24 January 2011

re:Sydney City Grid Stage 2D

Figure 3: Riley Street Construction Compound Indicative Layout.

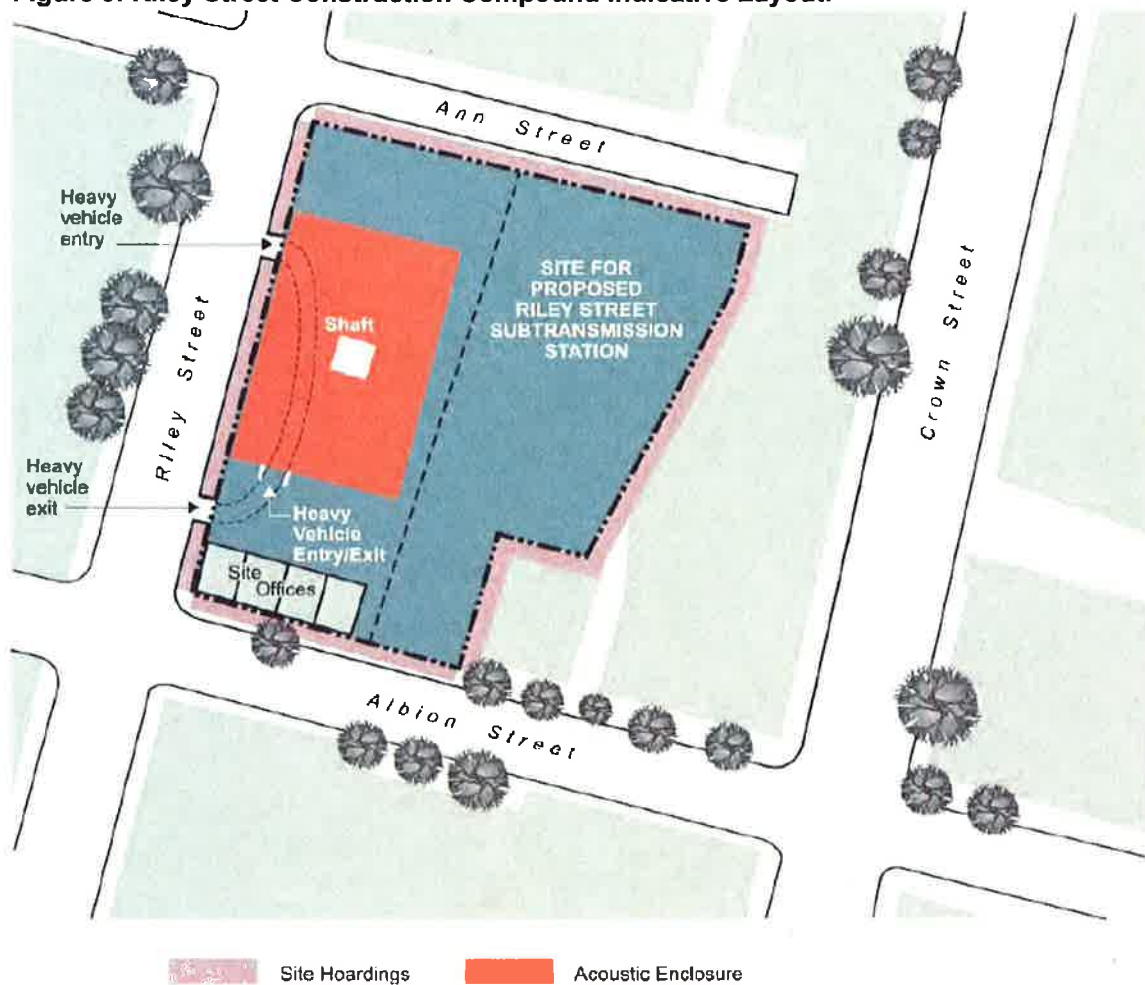
My bedroom window faces directly onto the proposed Riley Steer compound, therefore noise during the night and early morning are a concern. In particular I would not like to see vehicle movements prior to 7am.
